East Anglia ONE North and East Anglia TWO Offshore Windfarms

Applicants' Comments on Historic England's Deadline 3 Submission

Applicant: East Anglia TWO and East Anglia ONE North Limited
Document Reference: ExA.AS-19.D4.V1
SPR Reference: EA1N_EA2-DWF-ENV-REP-IBR-001199

Date: 13th January 2021
Revision: Version 1
Author: Royal HaskoningDHV

Figure 5: Outline Landscape Mitigation Plan and Relevant Heritage Assets in the vicinity of Friston

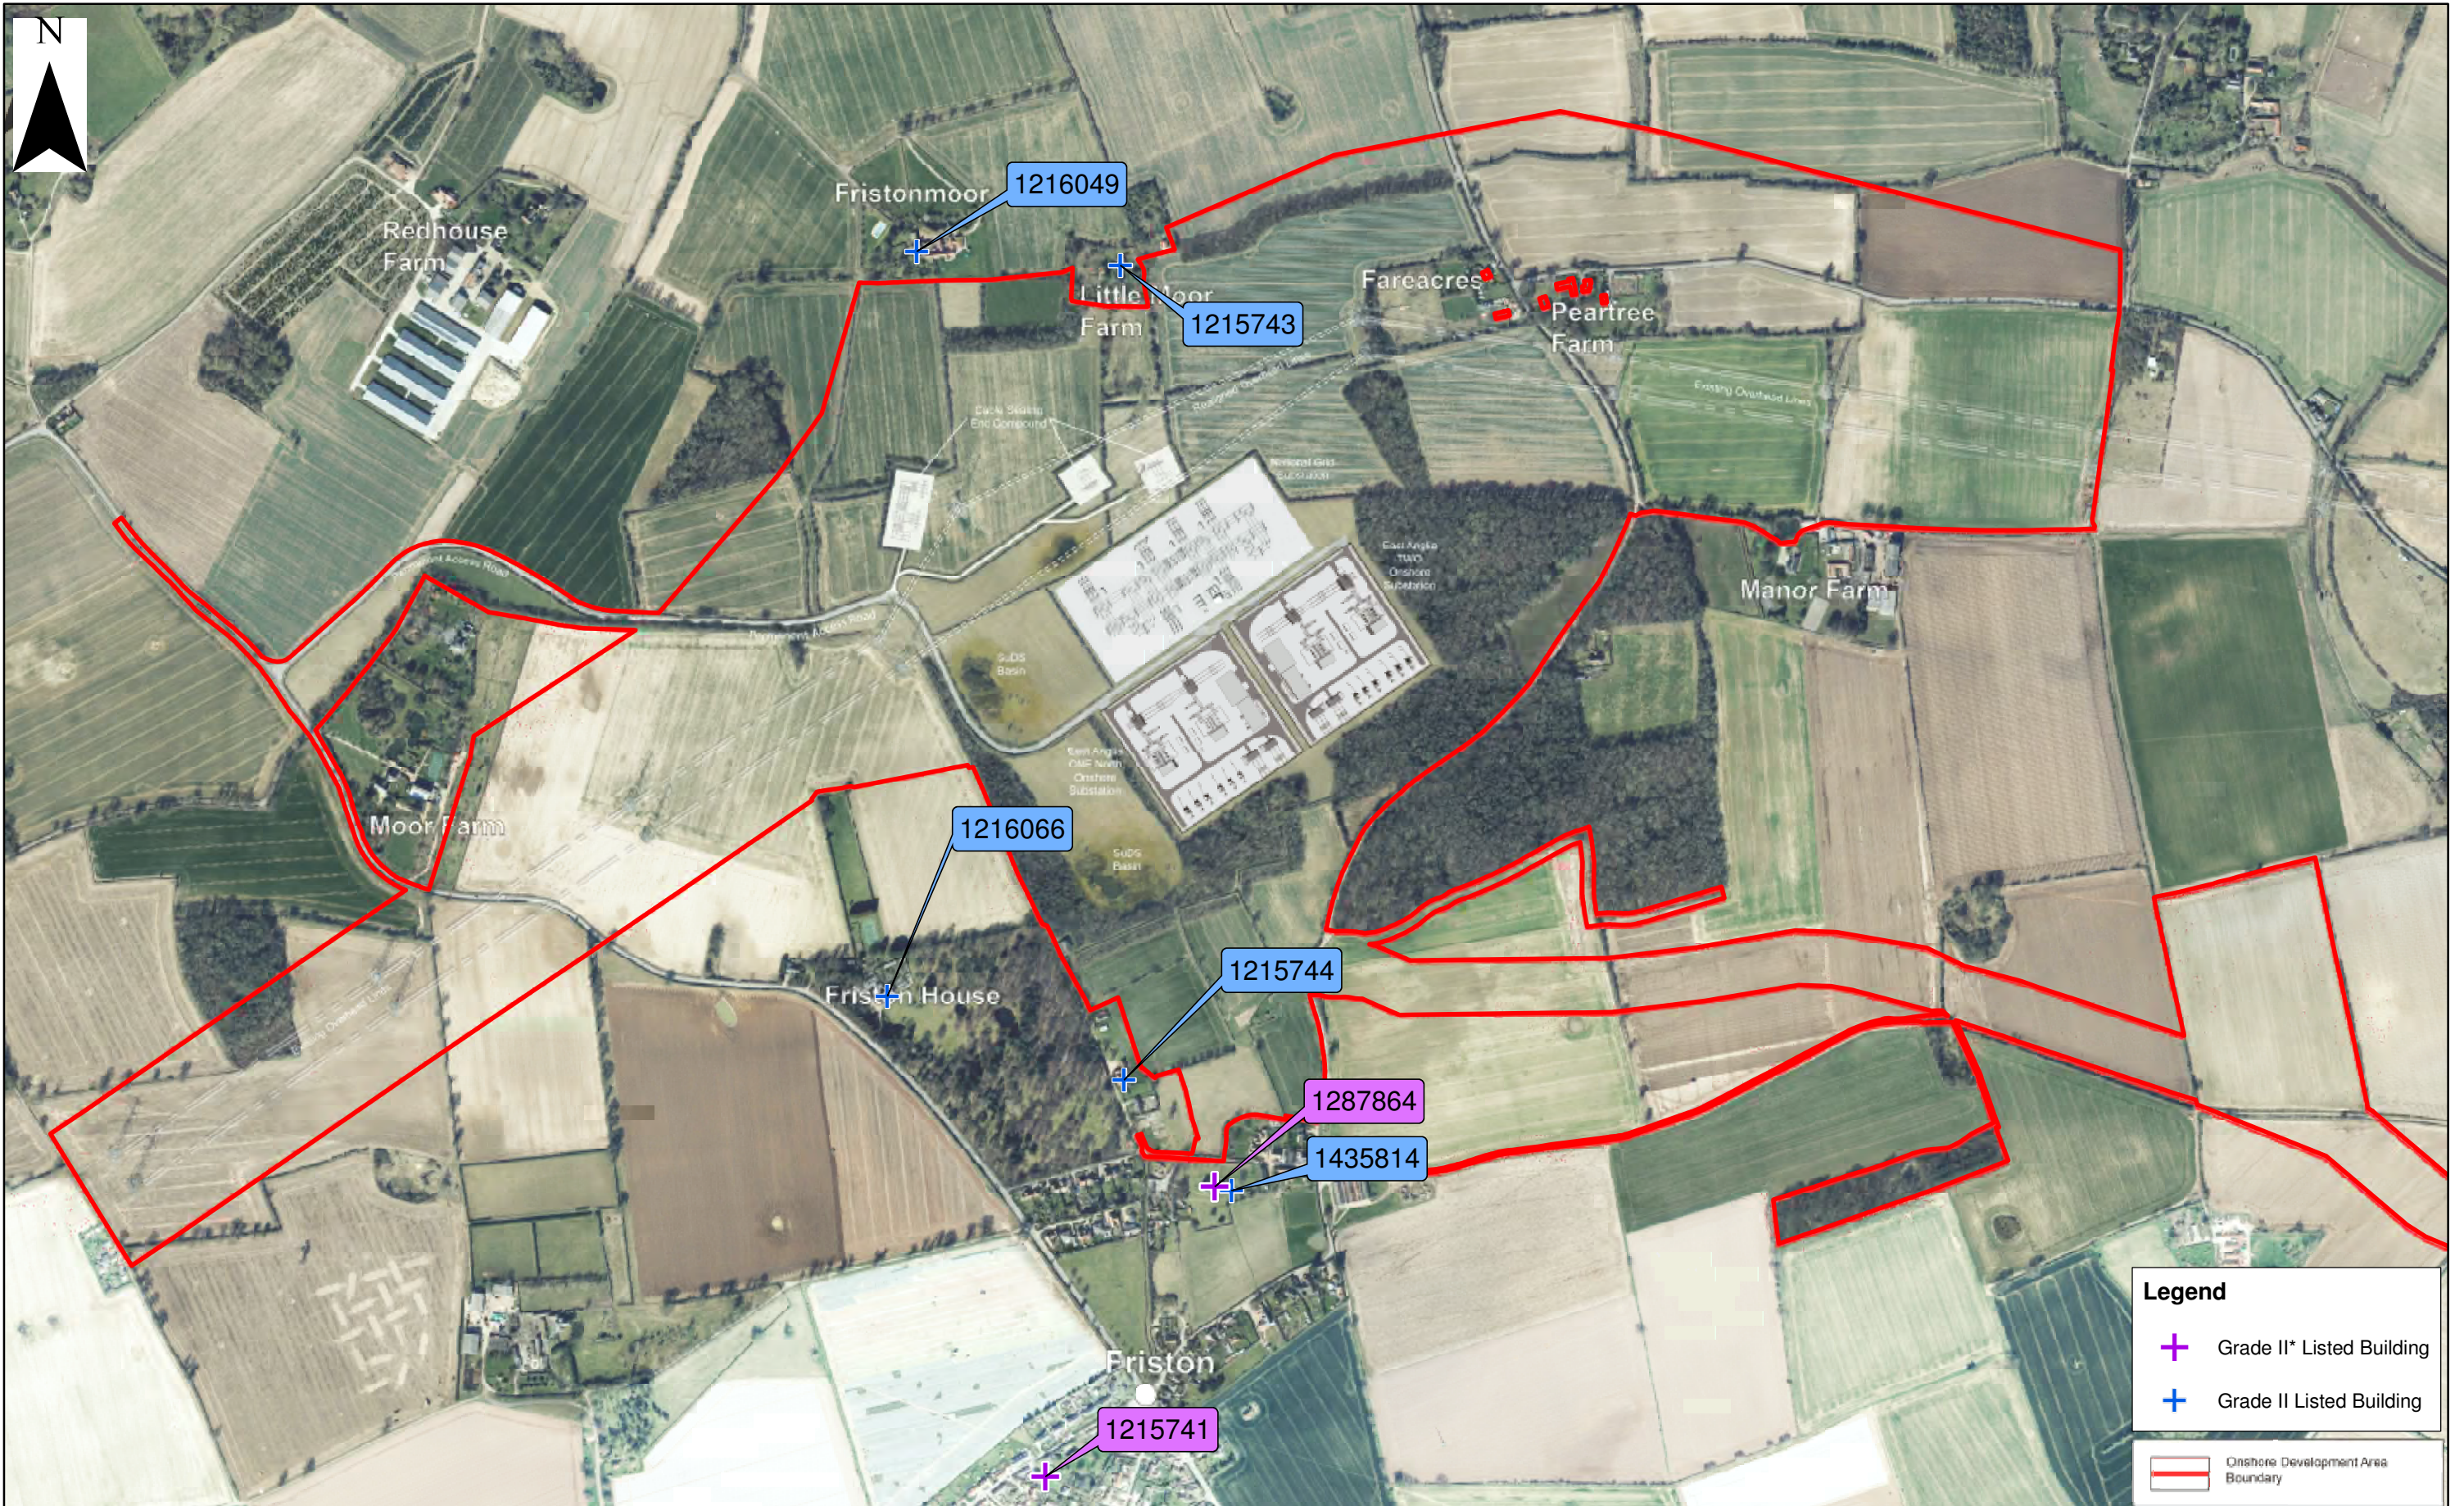
ID	HE Comment	Applicants' Response
	<p>In spite of the early discussion it continues to be a concern that this location was still considered favourable, and that given our advice more was not been done by the applicant to identify harm in relation to the church and then to seek ways better and more effect ways of reducing the impact of the development on the historic environment.</p>	<p>ensure that no particular environmental parameters were prioritised and that all were treated as equally important. Ultimately the RAG assessment did not identify the chosen onshore substation locations, but allowed a number of locations to be compared and the most acceptable to progress to more detailed assessment. At the time of completing the Phase 3.5 consultation the Applicants were considering the baseline cultural heritage information gathered and presented in the Archaeology and Cultural Heritage Desk Based Assessment (APP-514). Section 3.8 of (APP-514) includes a setting study, while Section 4.3 presents an assessment of effects from changes to setting.</p> <p>With respect to additional work undertaken by the Applicants, further clarity regarding potential harm to the church has been provided in the Archaeology and Cultural Heritage Clarification Note (REP1-021) submitted at Deadline 1.</p> <p>Additional changes have been made to the design of the onshore substations and National Grid substation which are described in the Project Update Note (REP2-007) and Deadline 3 Project Update Note (REP3-052).</p> <p>The Applicants also refer to the Heritage Assessment Addendum (document reference ExA.AS-11.D4.V1) and accompanying photomontages submitted at Deadline 4. This reviews the design changes set out in (REP2-007) and (REP3-052) (e.g. lowering of equipment / buildings heights) along with the greater retention of existing woodland around the onshore substations and additional planting included within the Outline Landscape and Ecological Management Strategy (OLEMS) (REP3-030) submitted at Deadline 3. These measures have led to a reduction in the influence of the onshore substations and National Grid substation in views in proximity to St Marys Church and the graveyard and</p>

ID	HE Comment	Applicants' Response
		also reduce the influence in views of St Marys Church from in and across Friston.
East Suffolk Council and Suffolk County Council Joint Local Impact Report		
3	<p>Just prior to the ISH we were also made aware of East Suffolk Councils and Suffolk County Council Joint Local Impact Report, dated November 2020. We have now had time to consider this in more detail, in particular the Built Heritage Chapter (12. pp67).</p> <p>As well as considering the significance of St Marys Church the councils have also considered the grade II listed buildings around the substation site, and the relationship of these assets to each other, and the landscape. Overall we consider this to be a sound piece of work and confirm we broadly support the conclusion that report has come to in relation to the impact of the development on the significance of these assets and the degree of harm.</p> <p>We particularly note at 12.11 the references to the parish and hundred boundary and the high degree of concern expressed in relation to the severing of an important historical route way between the outer and inner parish, and the loss of the key views of the church from the common land to the north.</p> <p>We have also identified in our Written Representation the views from the north of the as one of the critical issues with regards to the impact of the development overall and the additional research provided by the council and to some extent the applicant give further rise for concern in relation to both the contribution that this area makes to the significance of the church and the harm that would be caused to this significance by the development.</p> <p>As considered by the NPPF and the setting of heritage assets (Good Practice Advice in Planning Note 3) is that the settings of heritage assets</p>	<p>The Applicants refer to <i>Applicants' Responses to Examining Authority's Written Questions Volume 10 - 1.8 Historic Environment</i> (REP1-113) submitted at Deadline 1, in particular their response to Q1.8.14 regarding clustering and cumulative impacts. The Applicants also refer to their responses in <i>Applicants' Comments on Local Impact Reports</i> (REP2-013) submitted at Deadline 2.</p> <p>Since the submission of REP3-107 the Applicants have further explored the effectiveness of mitigation with Historic England through the Statement of Common Ground process. The design changes set out in (REP2-007) and (REP3-052) have been reviewed with Historic England, along with the revised visualisations submitted at Deadline 3 which show the additional planting now included within the <i>OLEMS</i> (REP3-030). Further planting north of the National Grid substation has been discussed; this has been included in the revised Outline Landscape Management Plan (document reference ExA.AS-14.D4.V1) and considered in the <i>Heritage Assessment Addendum</i> (document reference ExA.AS-11.D4.V1), both submitted at Deadline 4.</p>

ID	HE Comment	Applicants' Response
	<p>can change over time. We are also aware that our understanding of significance can also change as further analysis is undertaken and information emerges that helps our understanding of the value of a place or an asset. We feel it is therefore important to note that we feel that the consideration of the land to the north of the church has increased, and that through this research we better understand the important contribution it makes to its significance of the church.</p> <p>We are also aware that dispersed settlements such as that visible at Friston are very characteristic of the way in which villages developed in this part of Suffolk. Preserved patterns of dispersed buildings and other historic landscape features such as moats and farmsteads connect to the centre via trackway and foot paths are important survivals and indicators of historic settlement. Individual listed buildings to some extent cannot just be seen as isolated buildings in the landscape and this legibility and our ability to read and understand the landscape contributes much to our understanding of assets and their sense of place.</p> <p>We also therefore feel it would be reasonable to argue in this case, and as considered in other planning decisions that that harm to a number of individual designated heritage assets may accumulate. We think this is particularly apparent where it can be argued that these assets are connected. A development might result in harm to a number of designated heritage assets when taken individually, and that when the impact is considered on a group of interconnected assets this would amount to an accumulation of harm. This should include even less tangible and non-designated heritage assets such as landscapes, fields, boundaries and trackways.</p> <p>We also confirm that following comments provided at the ISH by the Council, we remain concerned about the potential efficacy of the proposed mitigation</p>

ID	HE Comment	Applicants' Response
	in relation to reducing heritage harm, particularly the proposed planting scheme presented by the applicant.	
Conclusion		
4	<p>Overall the church at Friston remains one of the key buildings in the community and over many centuries the church has played a key role in the life of the parish. Users of the church will have come from all areas of the parish, and this is evidence by the relationship between the church and the war memorial for example, but also about how a public building is experience and used by a community. It is also through the relationship of the church to the landscape that surrounds it, in particular this key area of land to the north where the development would be sited.</p> <p>We remain of the view that the development would be harmful to the significance of the church as a highly designated heritage asset in its own right, and this would be a high degree of less than substantial harm. This is explored fully in our written representation in relation to the development of the substations individually and in combination, and we find no reason following the evaluation of the additional evidence to change our view. We are however conscious that the significance of the of the church is not just about views, and it is our appreciation of the wider setting of the church that has emerged though the development process, and in particular the relationship of the church and other heritage assets through their landscape connections, and therefore the degree to which their setting is related. The accumulation of harm to a number of connected heritage assets is something that we feel should be given due consideration and weight.</p> <p>If there are any material changes to the proposals, or you would like further clarification in relation to our advice, please contact us.</p>	<p>Noted. The Applicants refer to <i>Applicants' Responses to Examining Authority's Written Questions Volume 10 - 1.8 Historic Environment</i> (REP1-113) submitted at Deadline 1, in particular their response to Q1.8.14 regarding clustering and cumulative impacts.</p> <p>Please also see the <i>Heritage Assessment Addendum</i> and accompanying photomontages submitted at Deadline 4 (document reference ExA.AS-11.D4.V1).</p>
